DAVID EVANS
AND ASSOCIATES INC.

January 6, 2020

SUBJECT: Response to Ogden Short Plat Resubmittal #2 SUB19-003, CAO19-005, SEP19-009 Lady Bug Trust Request for Information #2 Consolidated Land Use Applications for a subdivision of one lot into two lots, extinguish and create new easements, and steep slope alteration located within the shorelands.

OGDEN POINT SHORT PLAT
SITE PLAN

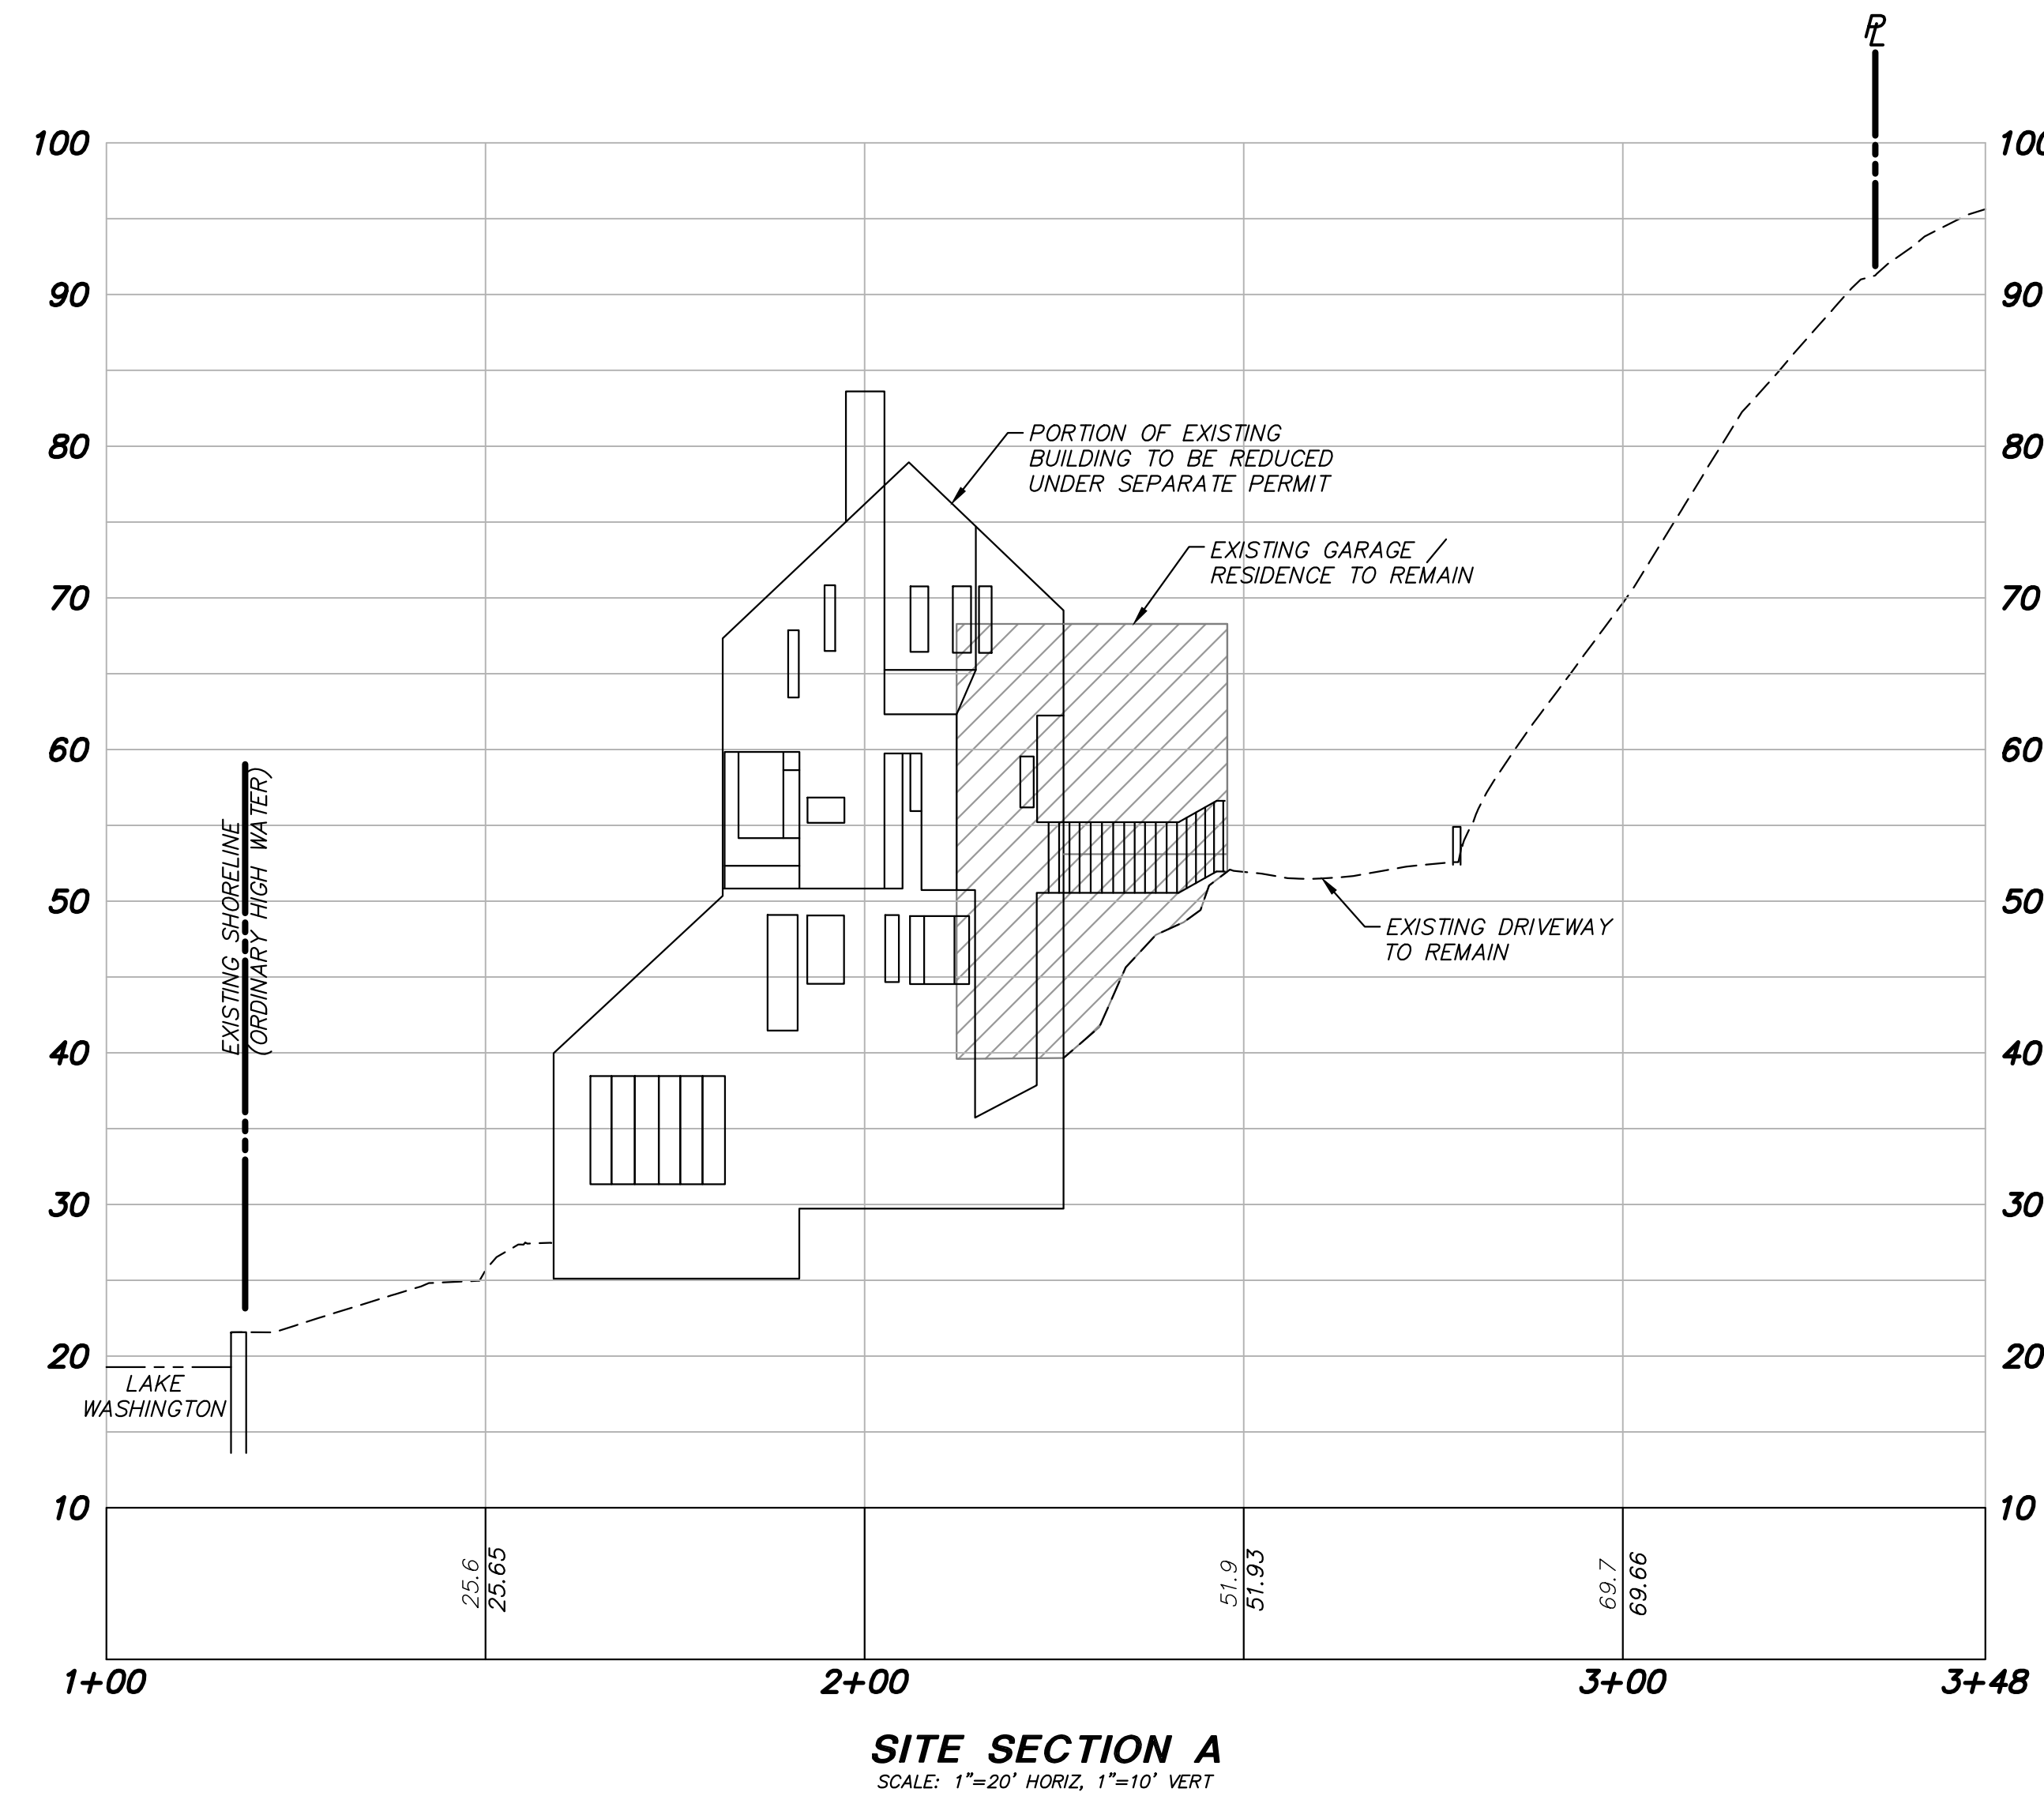
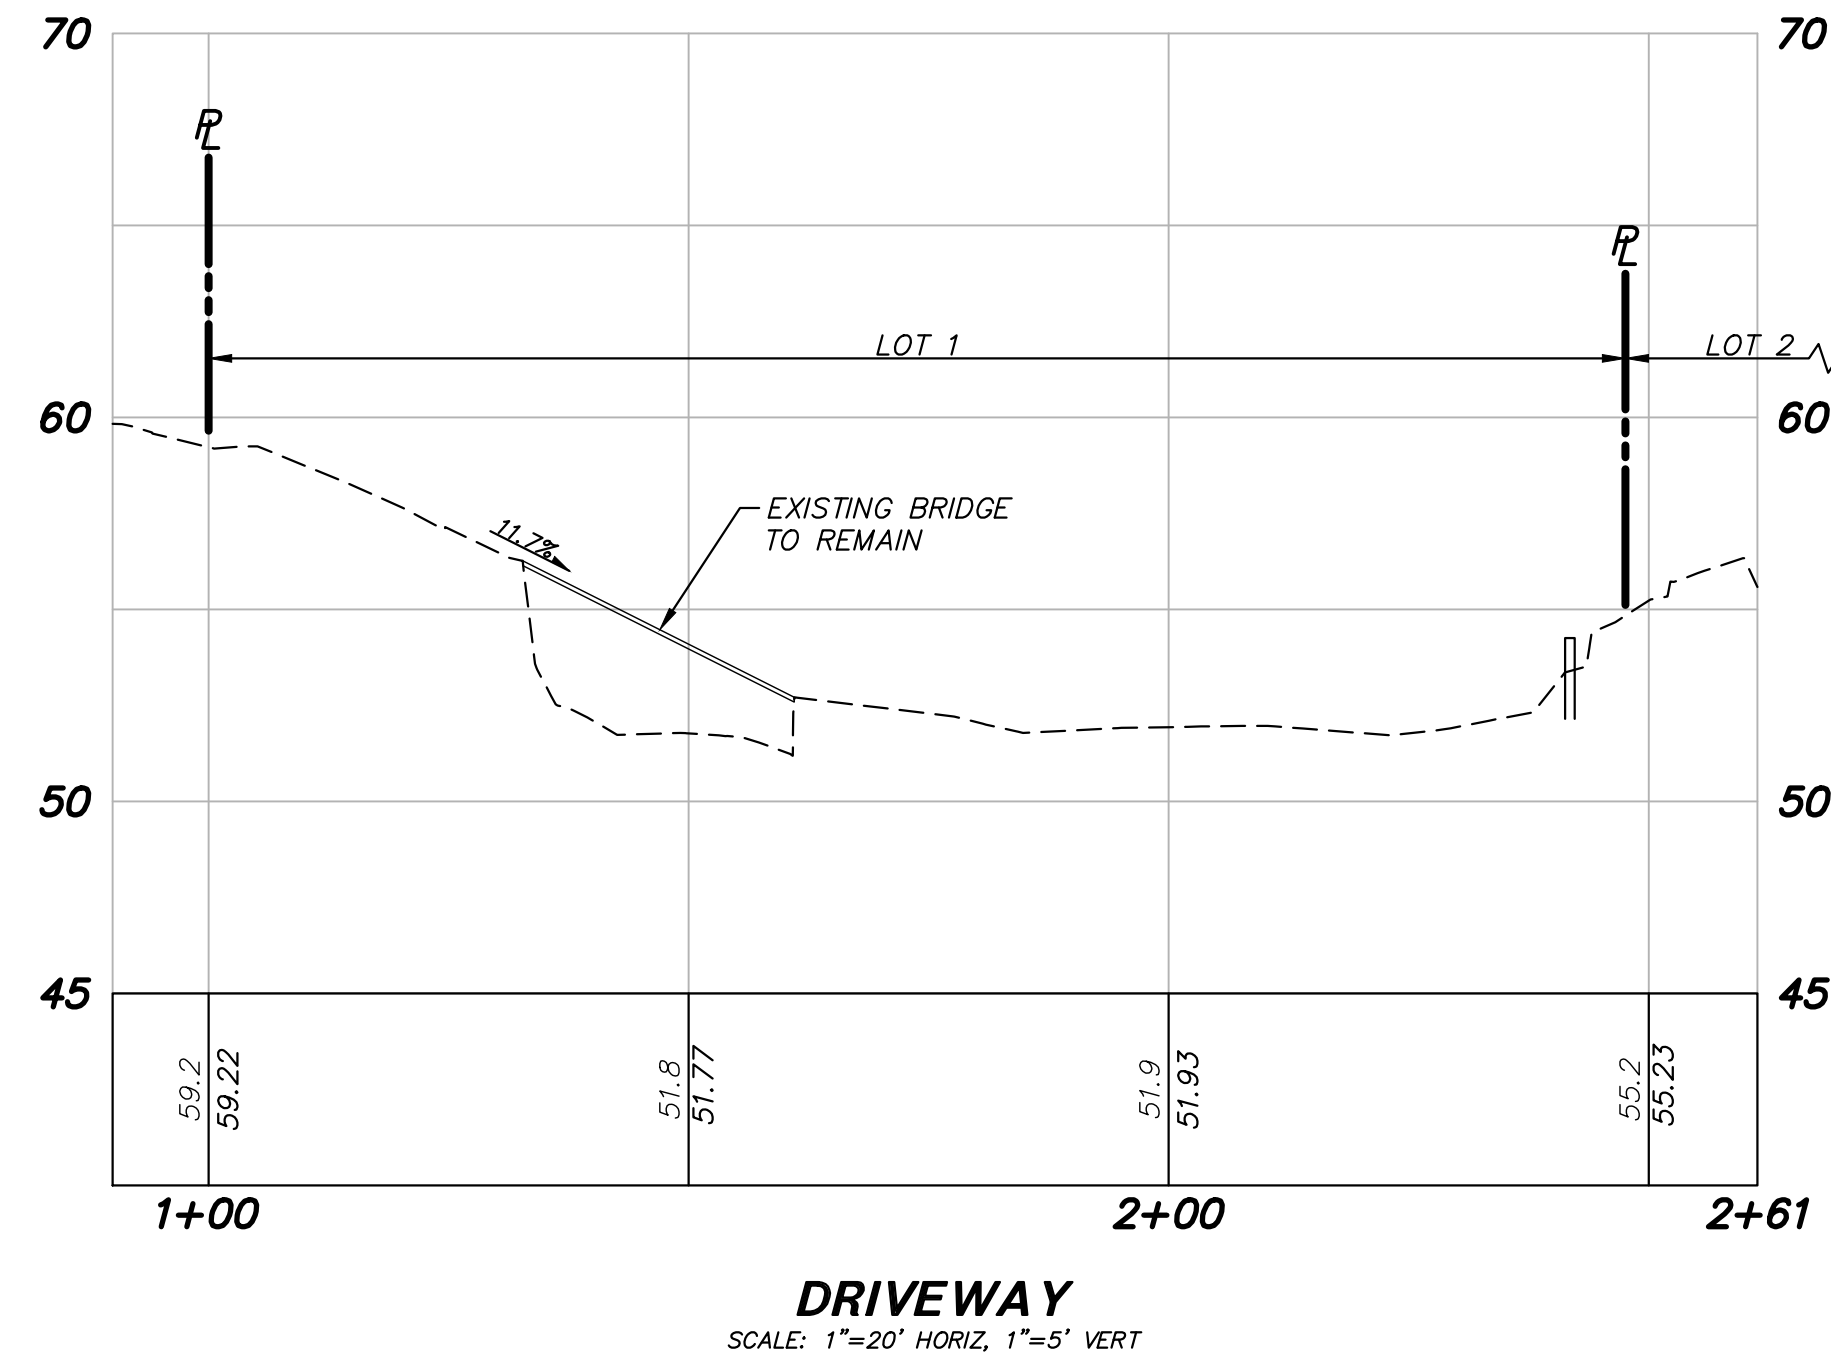
4. No cross-section dimension of a designated building pad shall be less than 20 feet in width, please revise the area labeled "Lot 1 Building Pad #2" to only include the area that meets the minimum width requirement per MICC 19.08.030(E)(3).
Lot 1 Building Pad 2 has been revised.

OGDEN POINT SHORT PLAT
 TREE PLAN
THE LADYBUG TRUST
OGDEN POINT SHORT PLAT
 SHORT PLAT APPLICATION
 CITY OF MERCER ISLAND, WASHINGTON

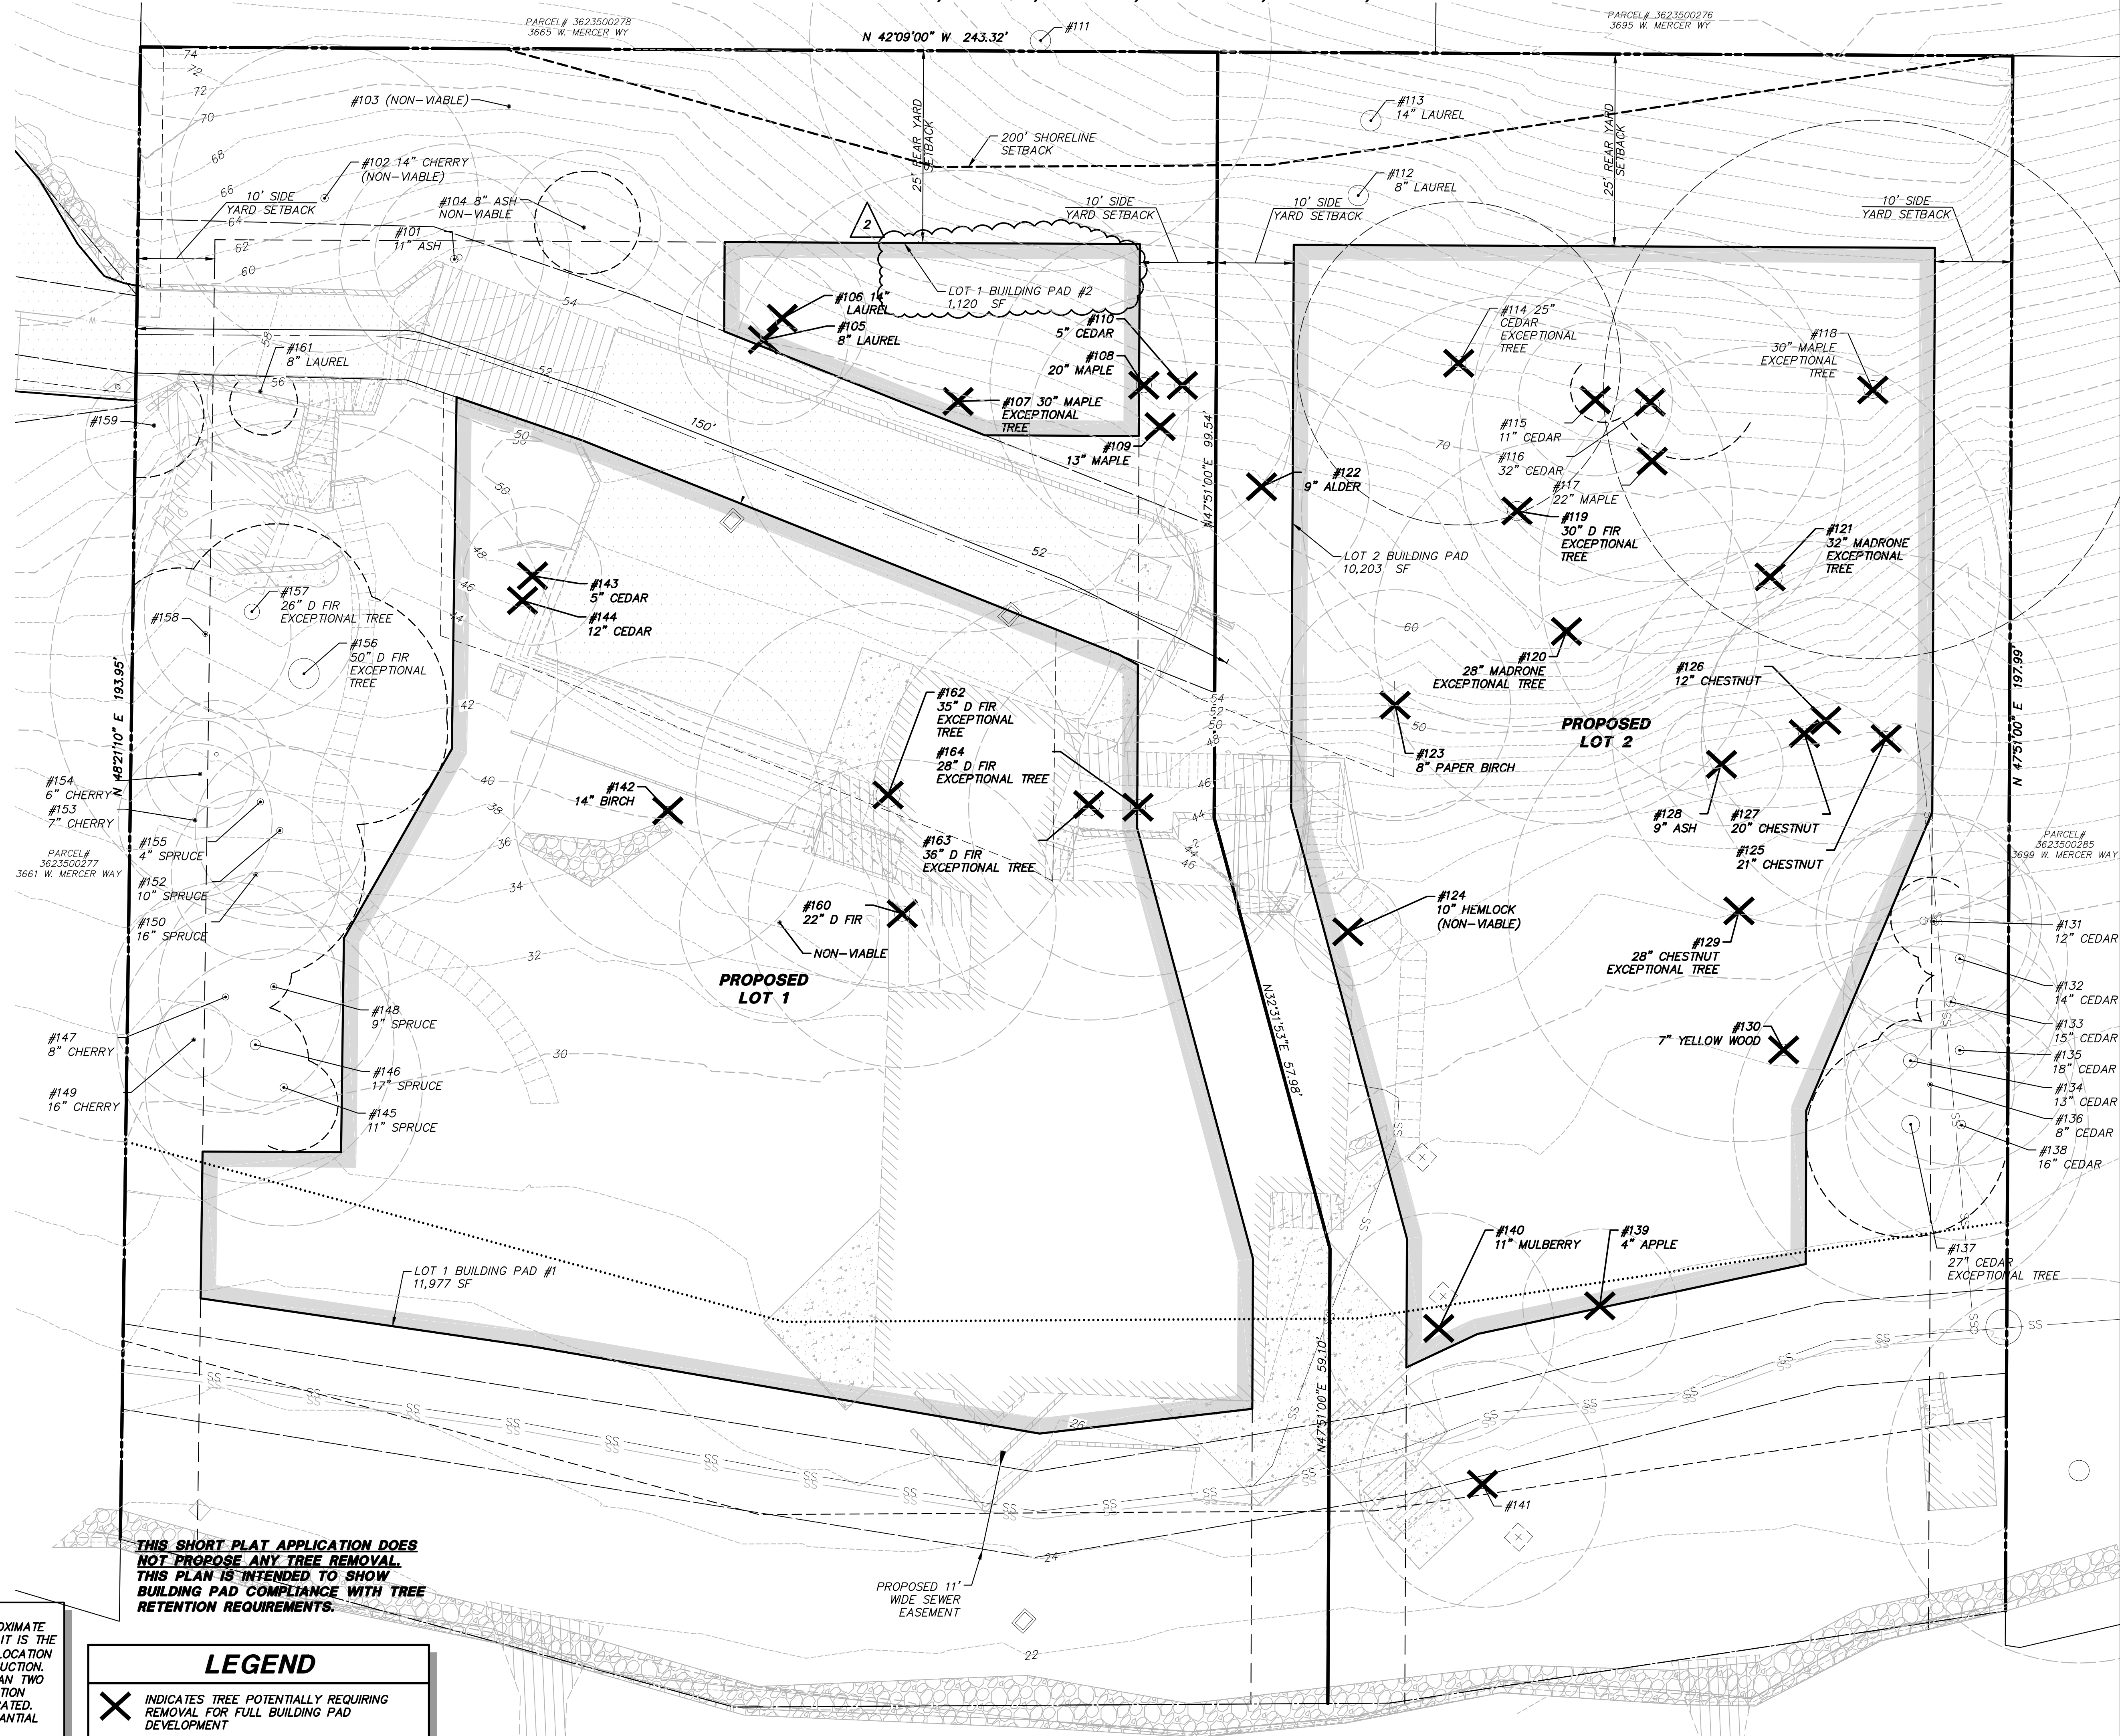
5. Repeat correction and clarification. The property is just one lot and the tree inventory worksheet shall be calculated for this one lot. Not two calculations for the proposed lot.
The previously submitted tree calculations were intended to demonstrate that the proposed building pads were compliant with tree retention requirements.

6. Provide Tree Inventory Worksheet showing retainage of at least the minimum required number of trees and Exceptional Trees. This calculation should be done for the current existing lot:
<http://www.mercergov.org/files/TreeInventoryReplacementSubmittalInformation.pdf>.
Tree calculations for the one existing lot have been included as requested. No trees are being proposed for removal during this short plat phase.

7. Include a conceptual replanting plan to mitigate for all removed trees on the preliminary plat. This will avoid any bonding requirements. Including the replanting plan during the preliminary plat phase will help ensure that there is enough area for the replanting and the proposed building pad area.
No trees are proposed to be removed and therefore no replacement trees are proposed.
